Your Ref:
Our Ref: BR/54/09/
Please ask for:
Ms A Paice

The Town and Country Planning Act 1990 (as amended)

Rear and side single storey extension
7 Parkway Bognor Regis

PROPOSED GROUND FLOOR PLAN

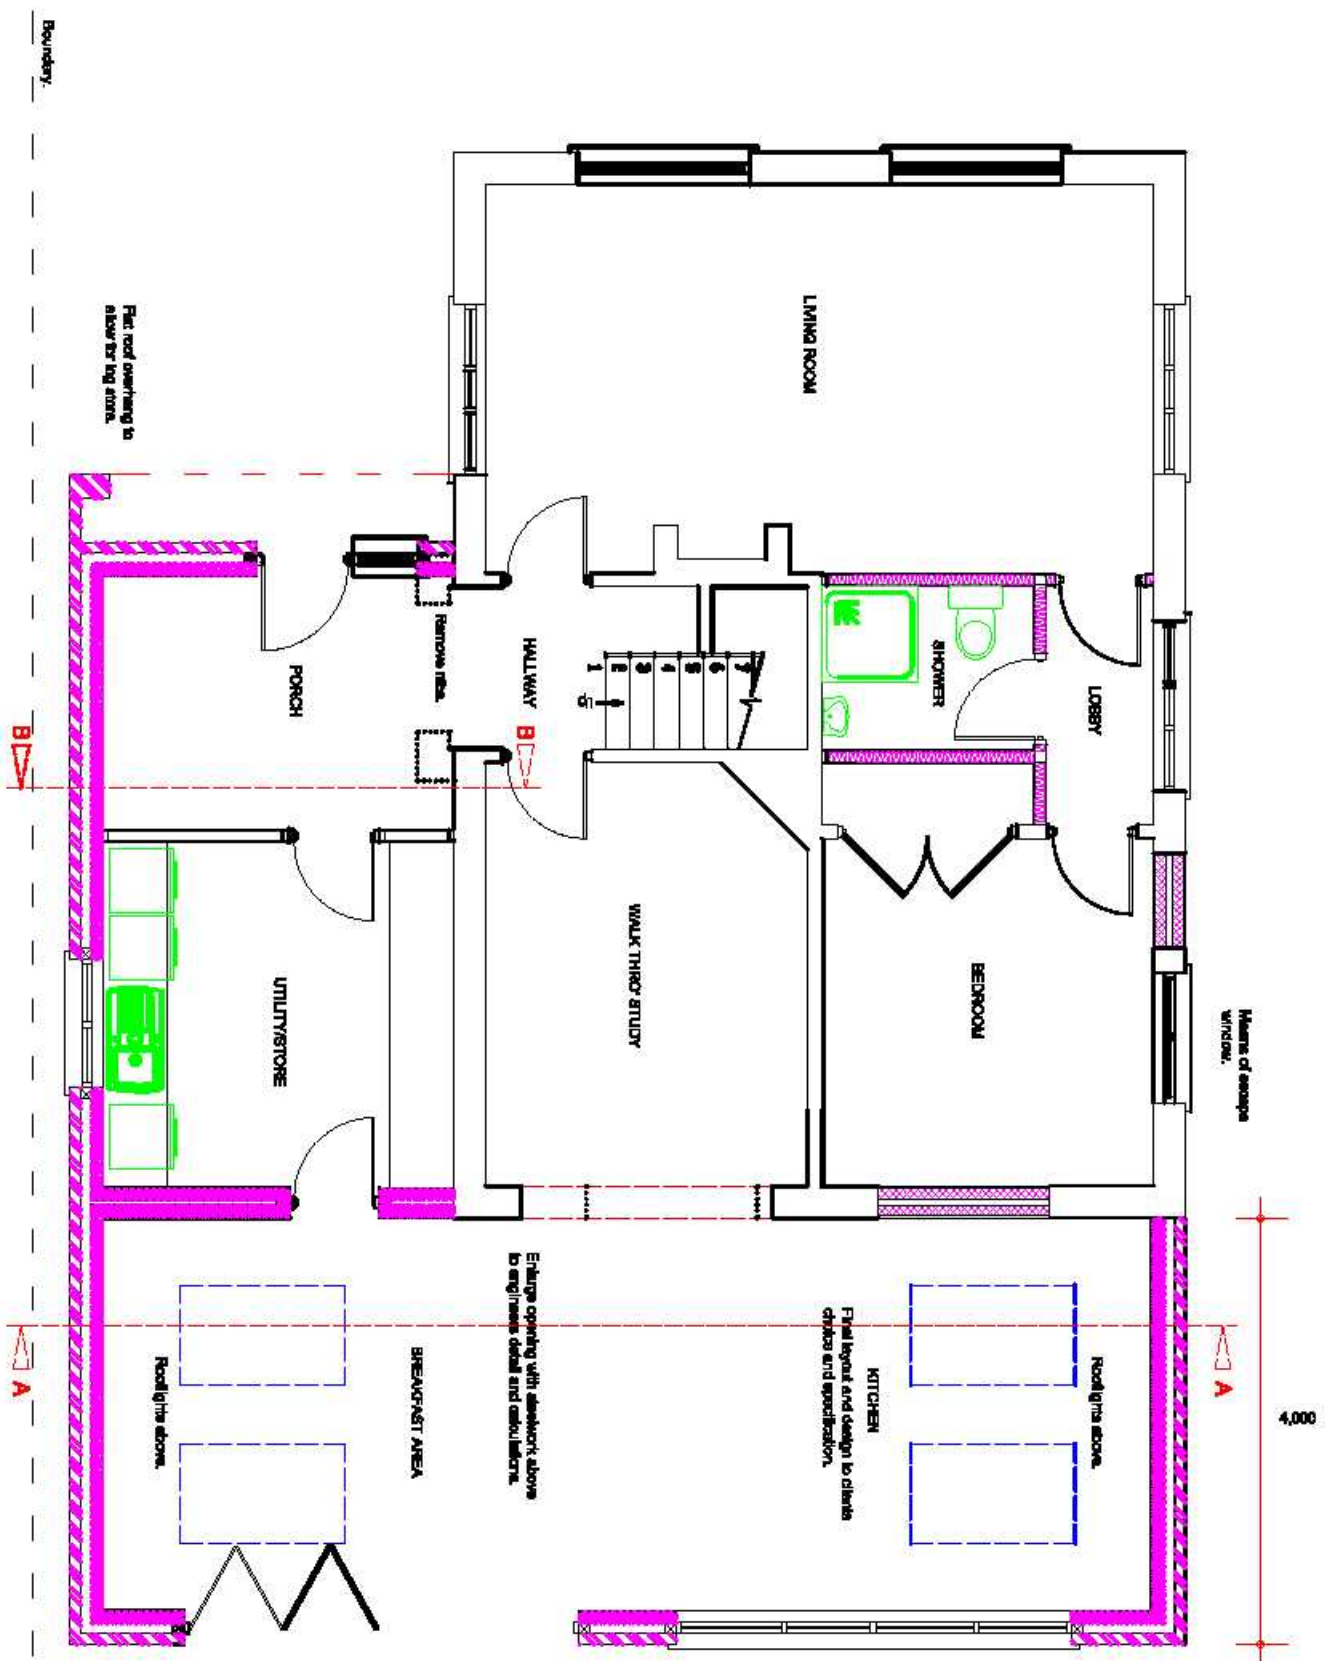
NO OBJECTION but concerns were expressed over the proximity of this extension in relation to the neighbouring property
